APPLICANT'S RESPONSES TO RELEVANT REPRESENTATIONS AND ADDITIONAL SUBMISSIONS

Drax Bioenergy with Carbon Capture and Storage

Document Reference Number: 8.3

PINS Reference: EN010120

DRAWING NUMBER
DBA - FIGURE 1

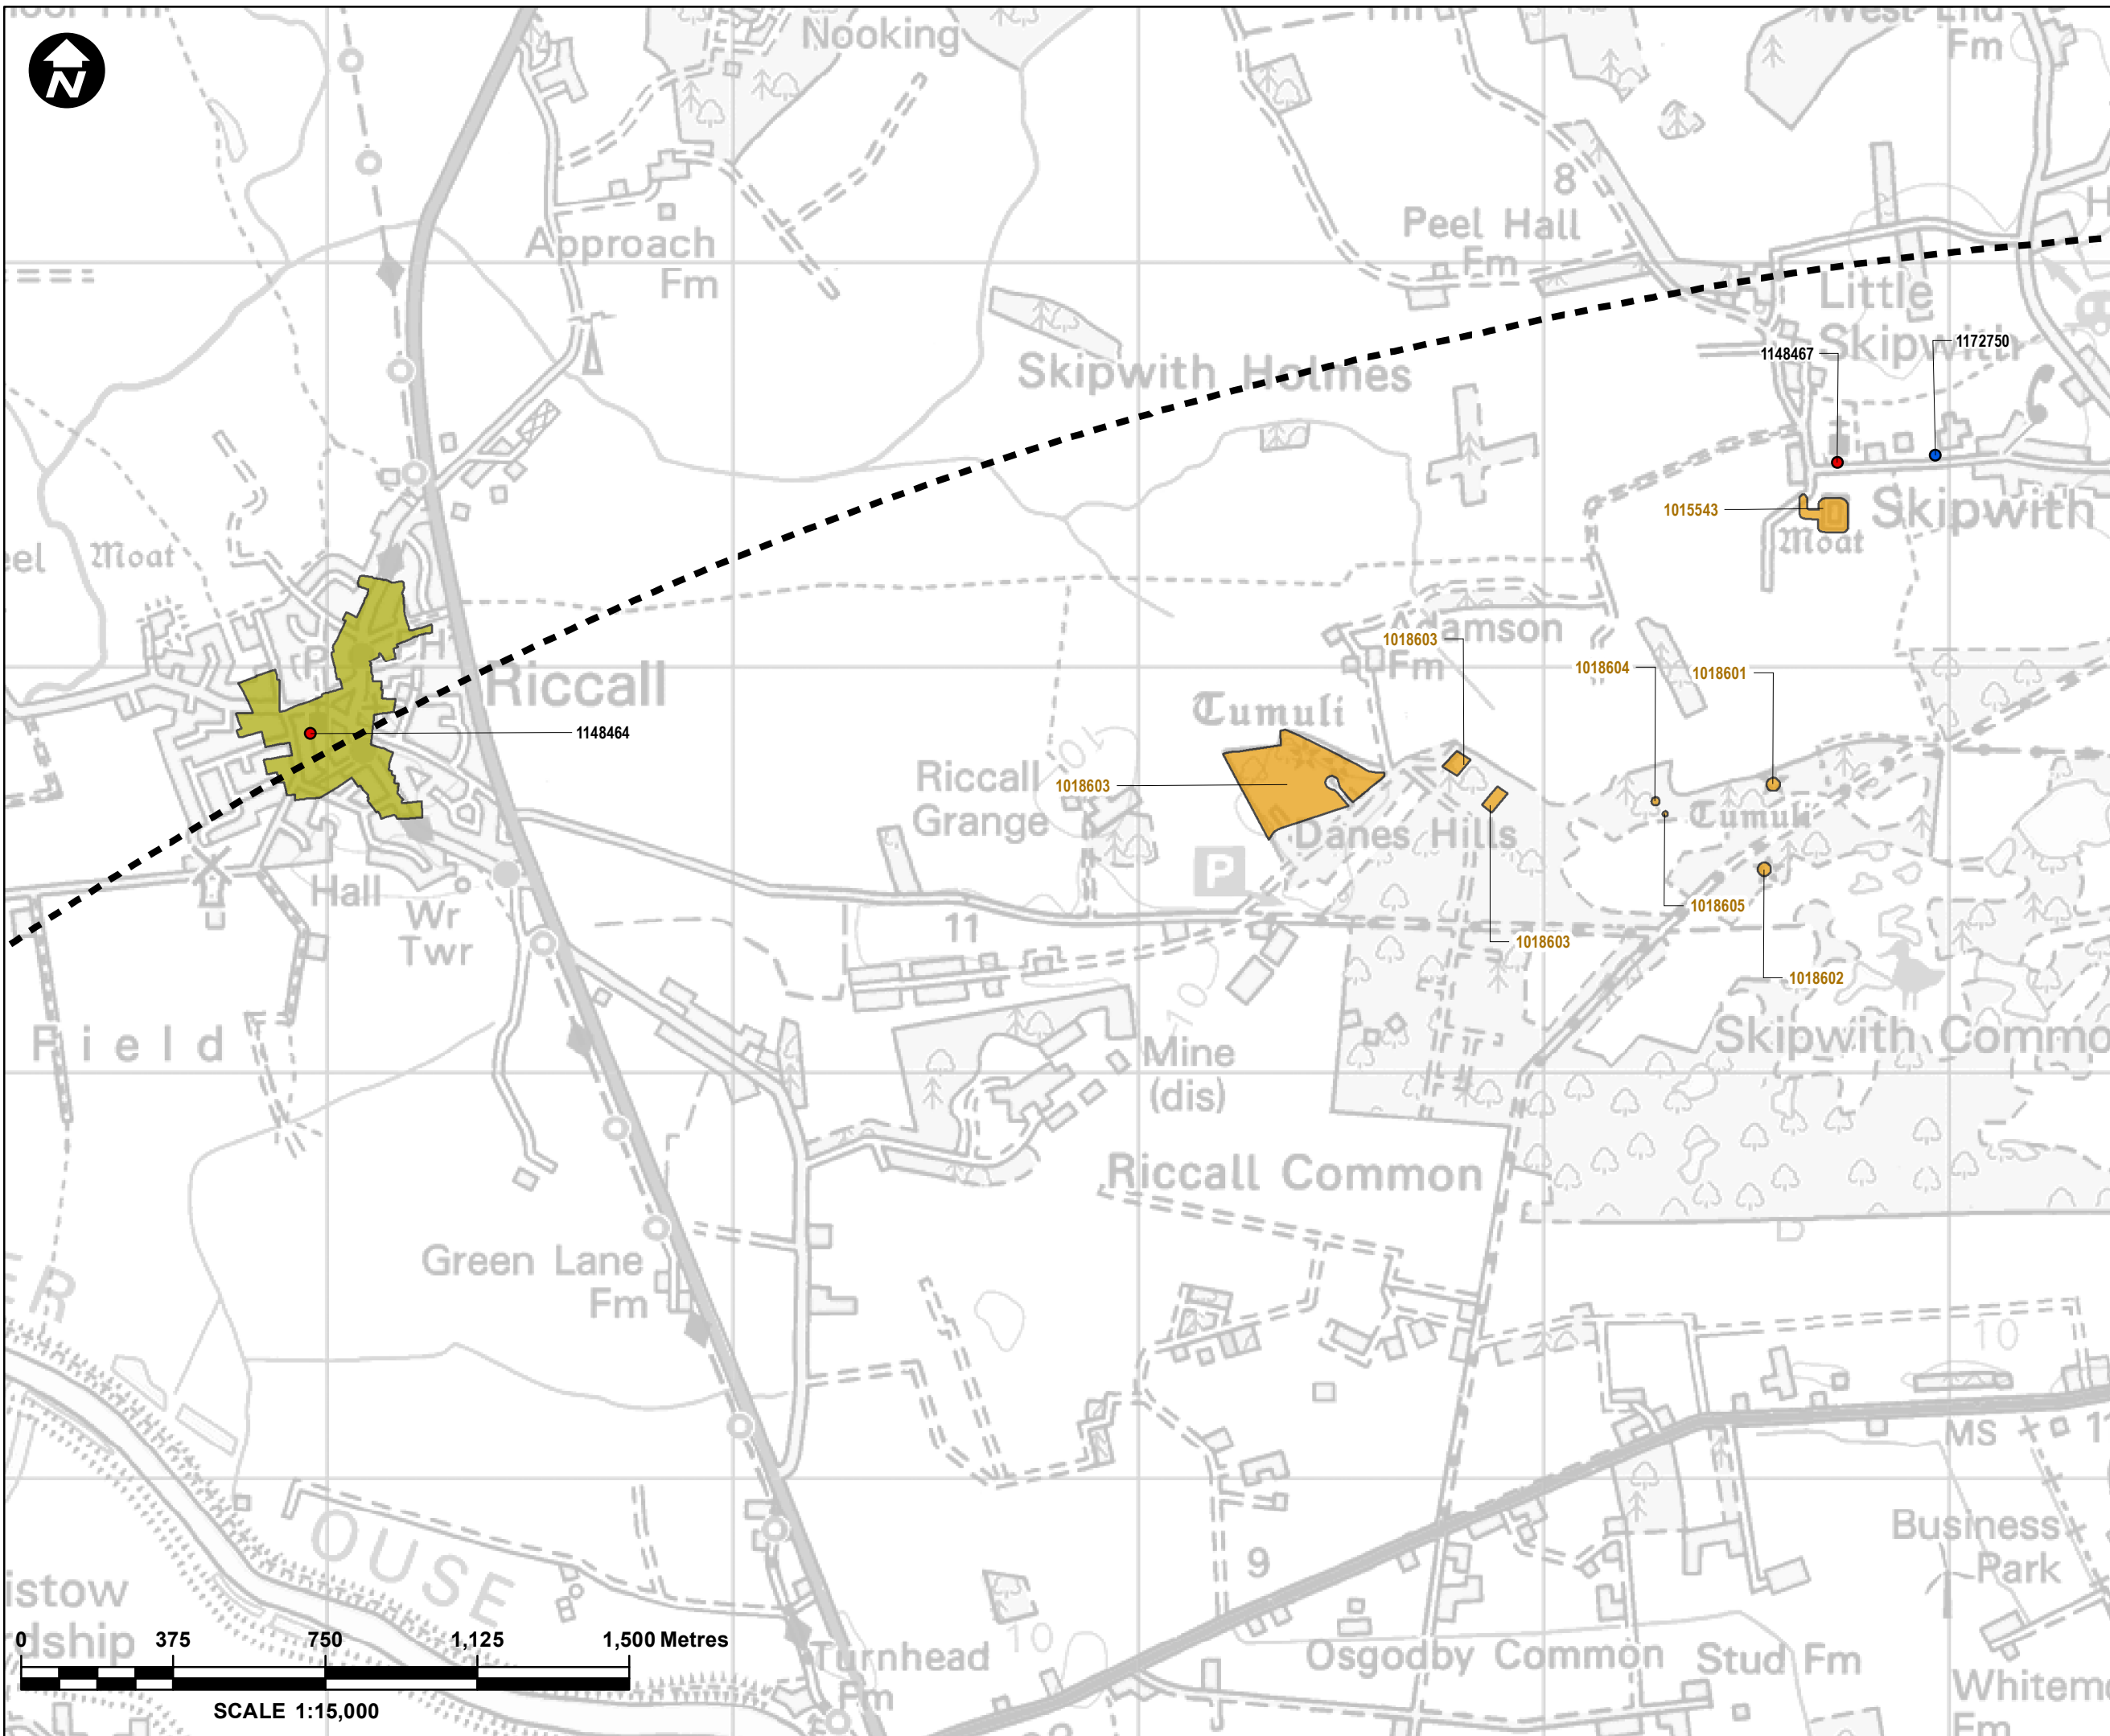
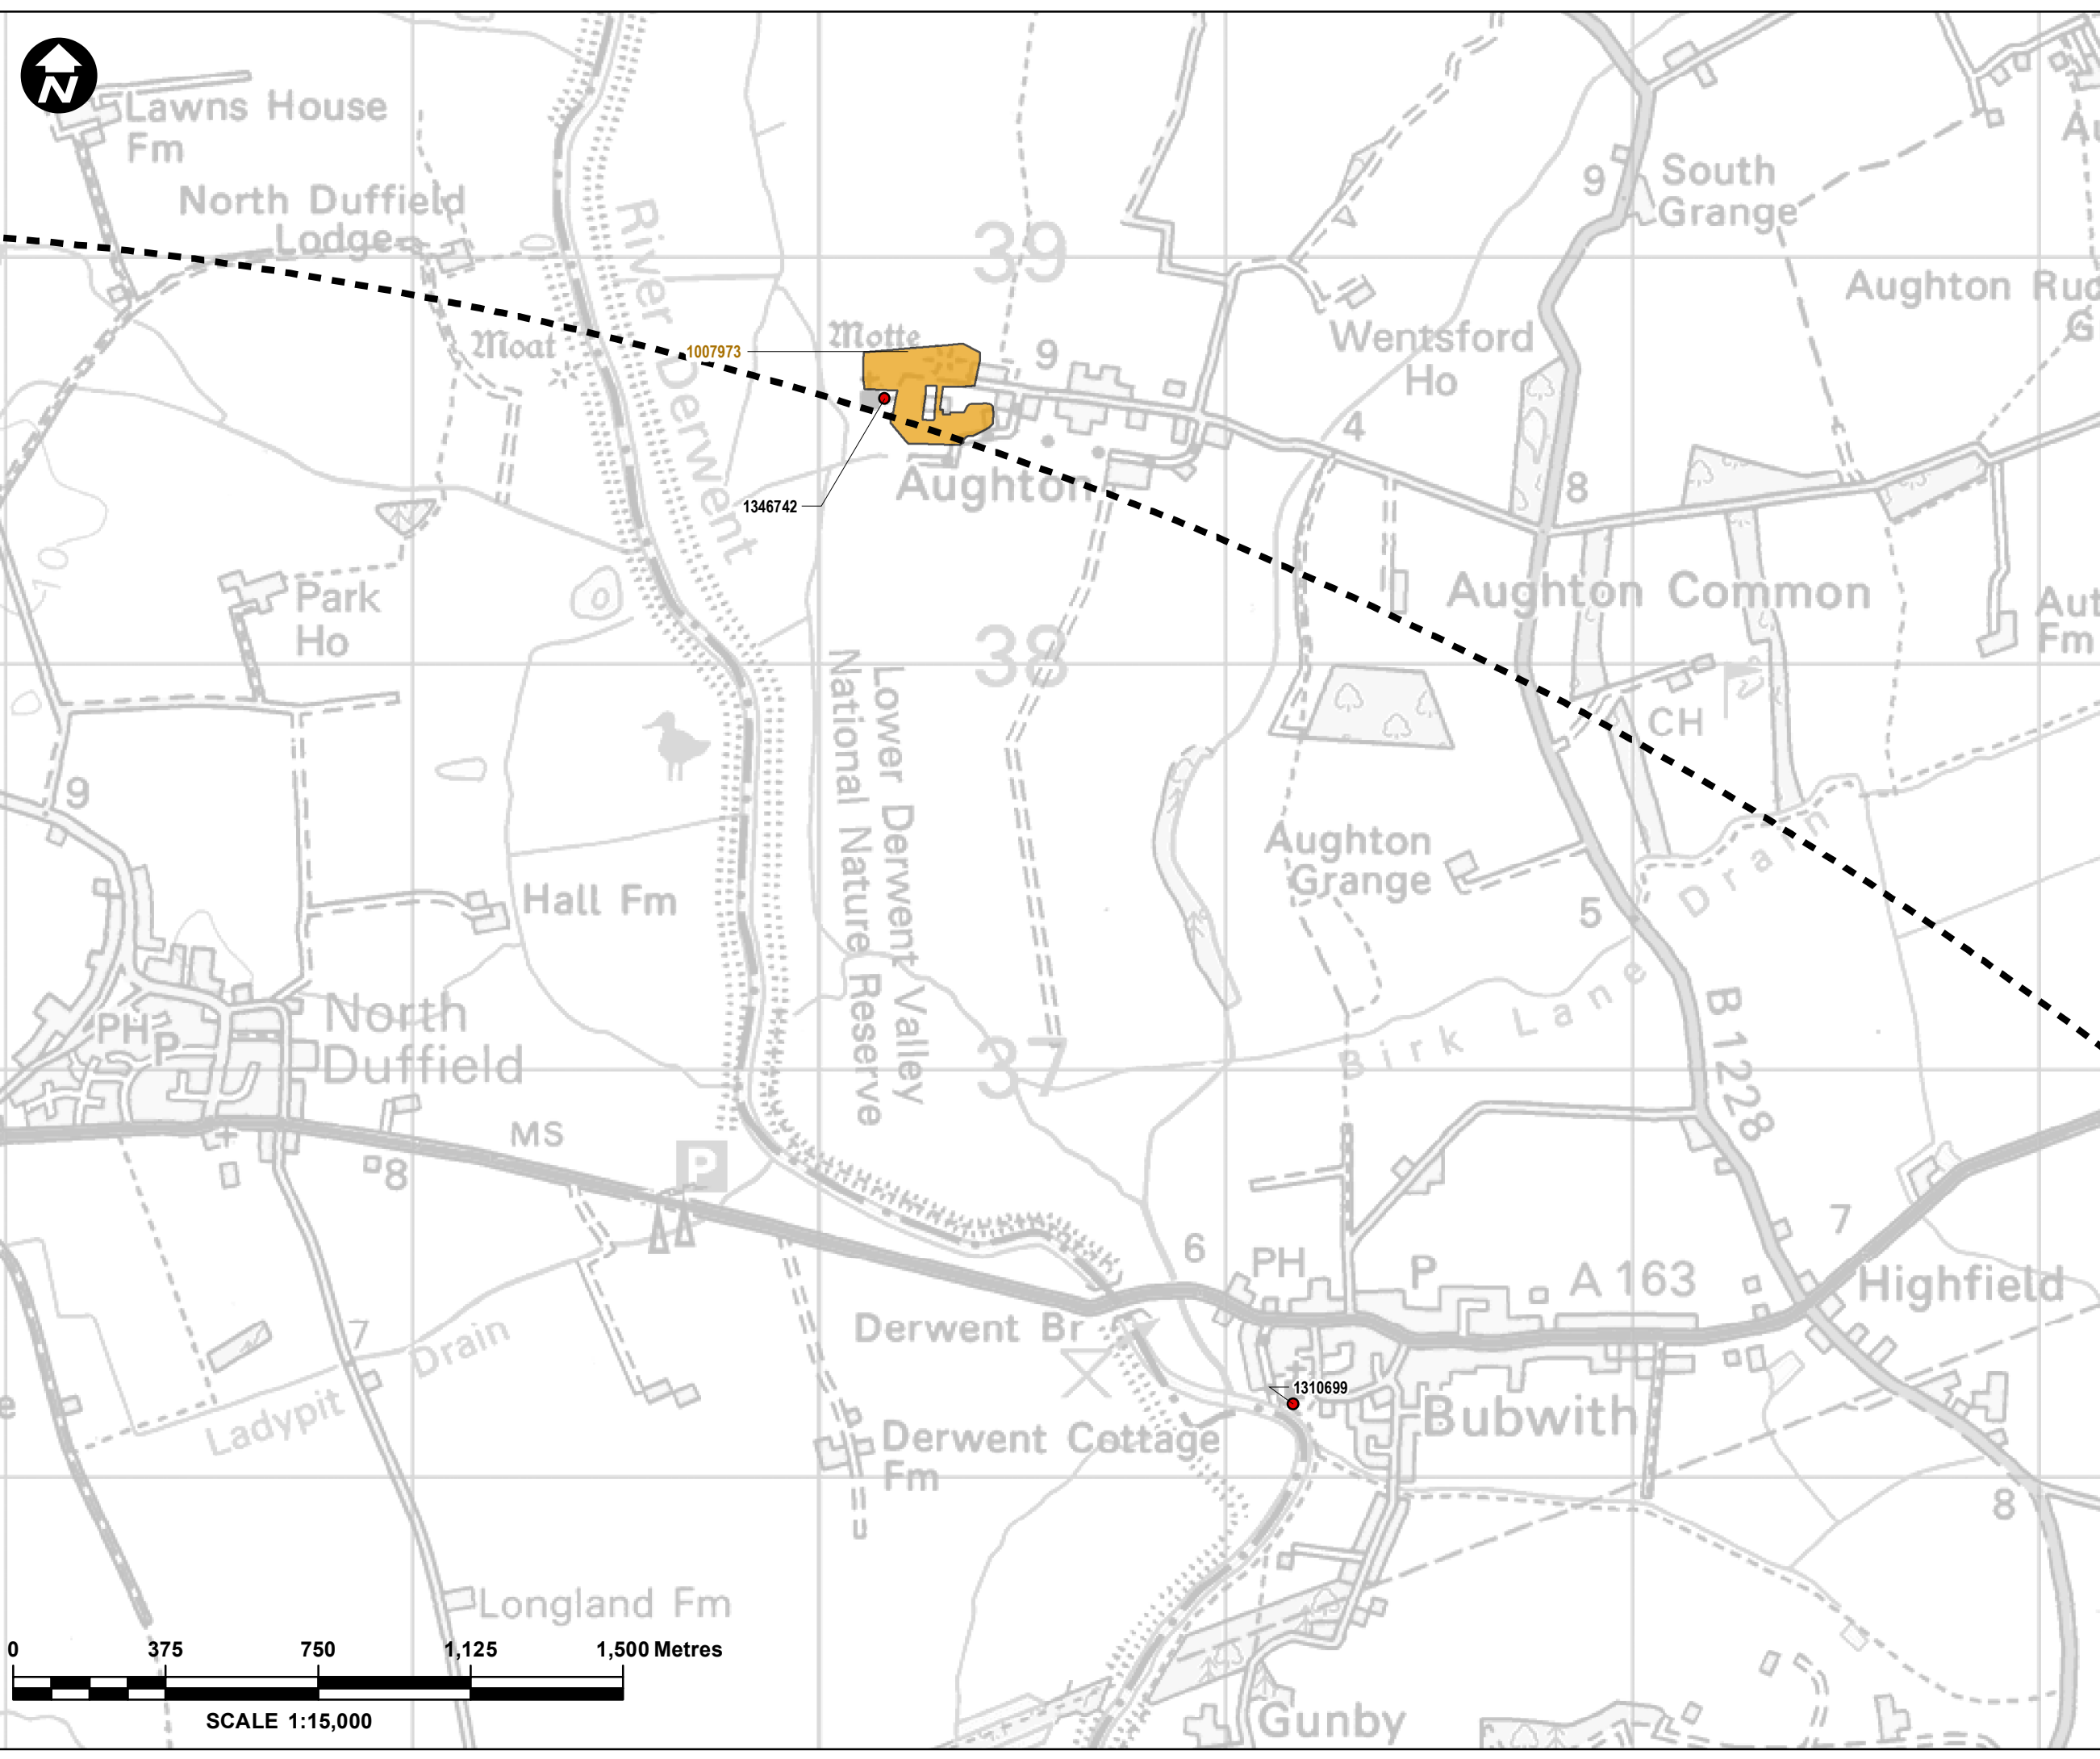
2.11 Heritage (SDC)	<p>The Environmental Statement has included a Heritage chapter, it identifies Grade I and Grade II* listed buildings plus scheduled monuments. Grade II listed buildings do not appear to be shown on the designated heritage asset map (they are mentioned in the Heritage chapter being located in the 1km study area). Non-designated heritage assets have been identified. The viewpoint document shows how the new development will appear in context with the existing structures.</p>	<p>The comment is noted. The Applicant intends to reissue a version of the designated heritage asset map that includes Grade II listed buildings at Deadline 1.</p>
